Planning Application No: 3/2022/0469

Proposal: Outline planning application for the erection of three new residential dwellings.

Location: The Warren, Warren Fold, Hurst Green BB7 9QH

EXISTING SITE PLAN

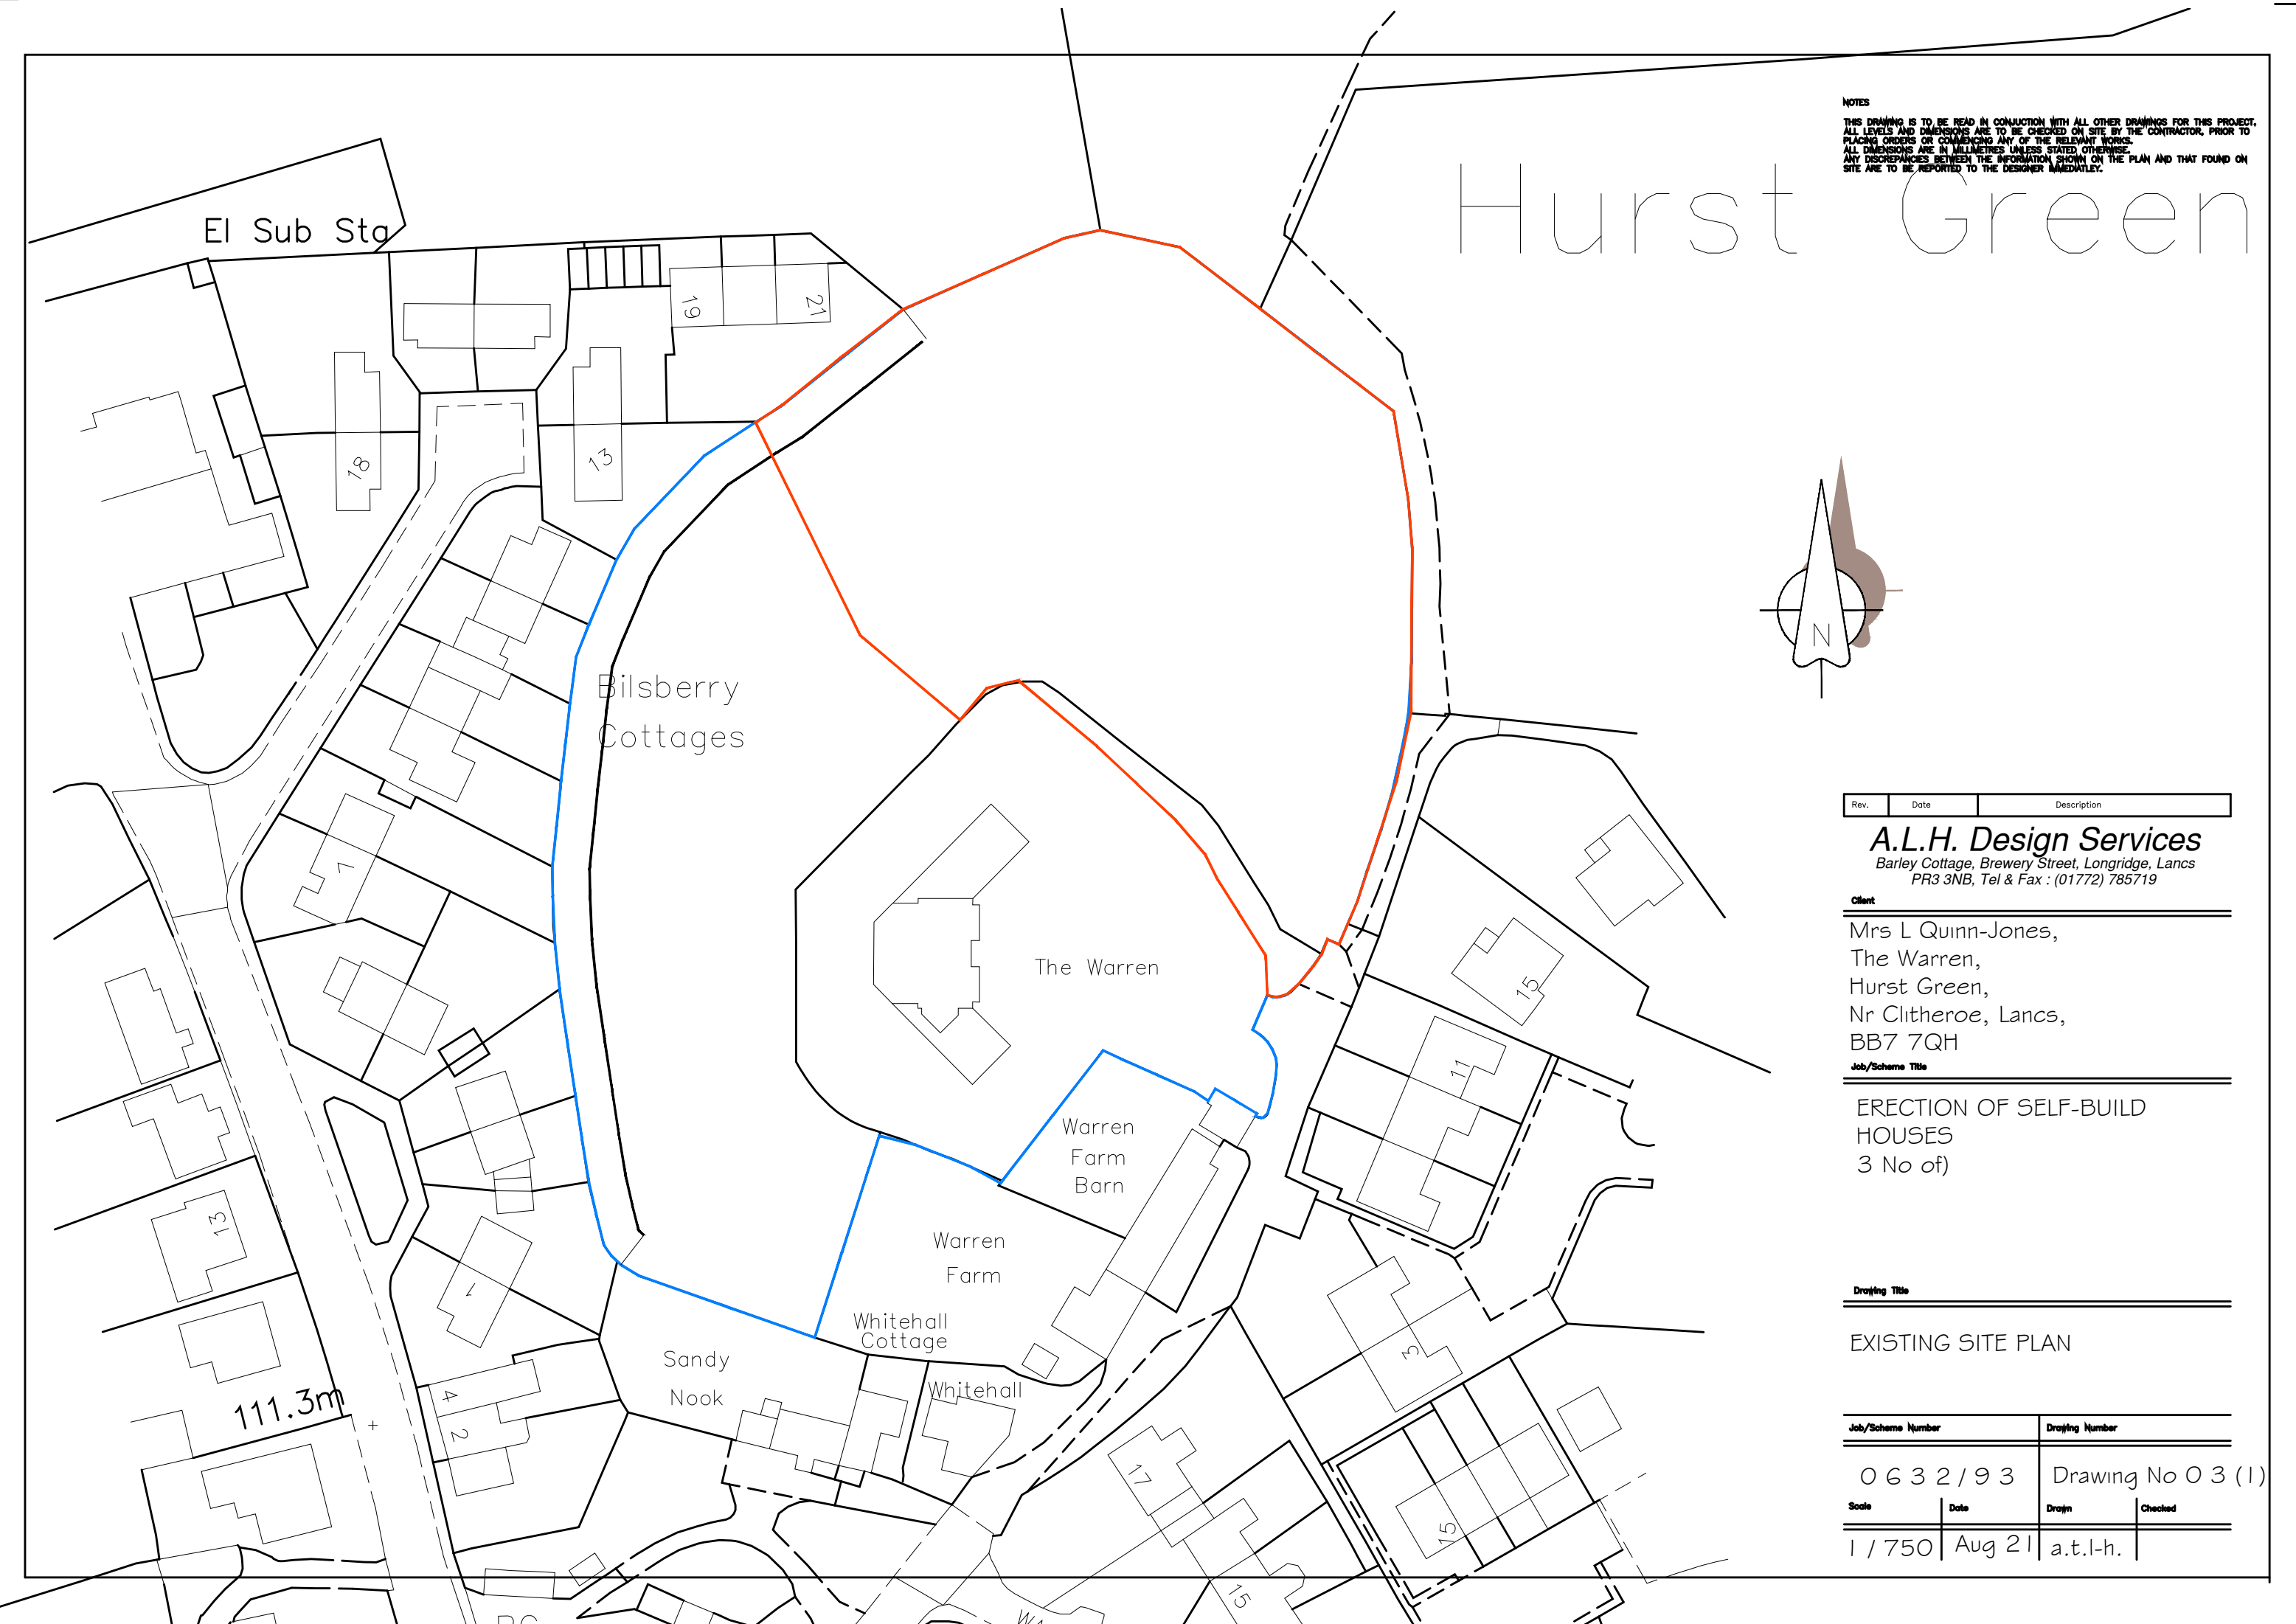
Access to the proposed development site is from the adopted highway network on Warren Fold via a privately maintained track leading to the North and providing vehicular access to three existing residential properties, together with access for agricultural vehicles to the field to the East of the development site. It was noted at the time of the site visit that the track to the field had been in recent use.

The proposal would double the number of properties served by the track from Warren Fold. This raises concerns given the pinch point on the first section of this track from the adopted highway network to Warren Farm, with limited forward visibility. However, this section is short, and vehicles would be travelling at low speeds. As the carriageway on Warren Fold is wide enough to allow two-way traffic and the track widens outside Warren Farm traffic movements could operate on an informal give and take basis, as may already happen.

The highway authority recommends that at Reserved Matters stage a revised access layout is submitted. This should be widened and extended from the existing access to The Warren to be similar to the southern layout of the existing access and widened further back into the site. This would improve access for larger vehicles serving the site.

That section in front of the new access, and which is currently unmade, should be surfaced in a bound porous material. Although not shown within the blue edge on the submitted Location Plan, details held at the Land Registry (Title Plan LAN117294) indicate that this area is within the applicant's ownership.

*Figure 5. Proposed site layout (extract of drawing prepared by ALH Design Services)*

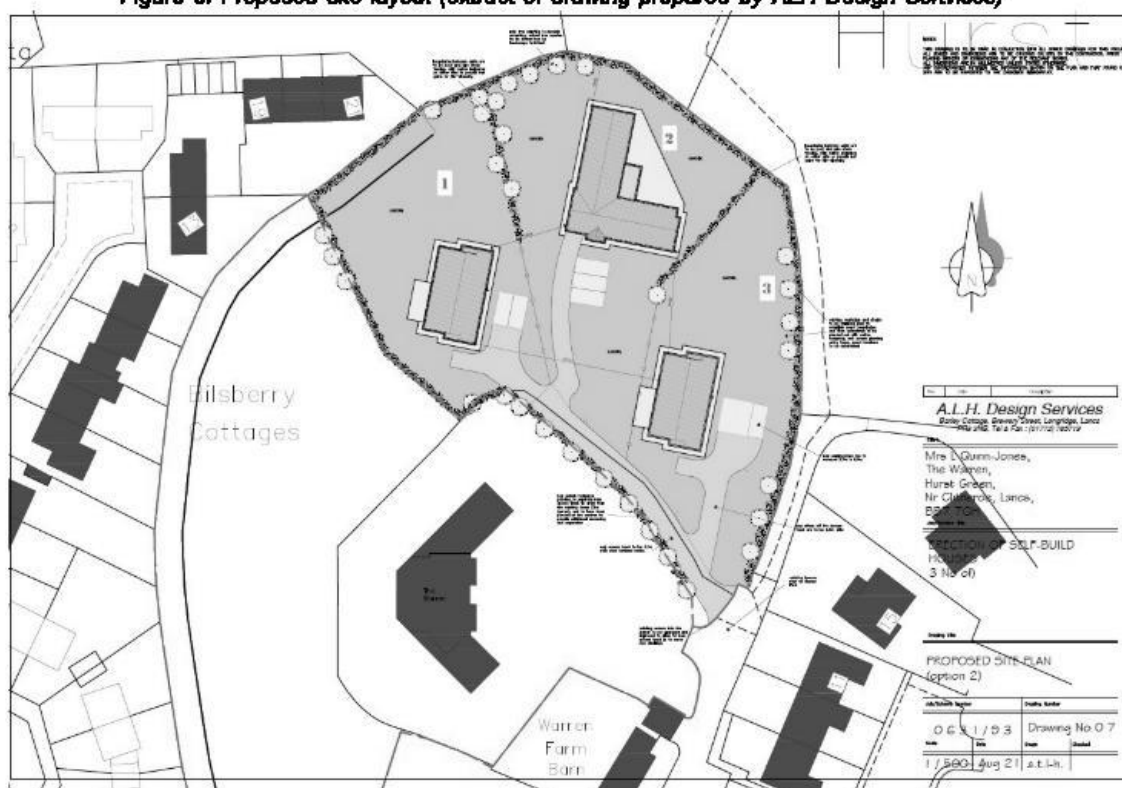
The submitted internal layout is indicative only but the following comments should be noted.

At Reserved Matters stage a swept path plan for a refuse vehicle should be submitted demonstrating that it can enter and leave the site in forward gear.

A swept path analysis for a refuse vehicle should be provided to demonstrate that a refuse, emergency or large delivery vehicle can enter and leave the site in forward gear, for the following reasons:

- The maximum recommended distance a refuse vehicle should reverse is 12m (Manual for Streets).
- Fire and Rescue Services vehicles should not have to reverse more than 20m from the end of an access road. (Manual for Streets).
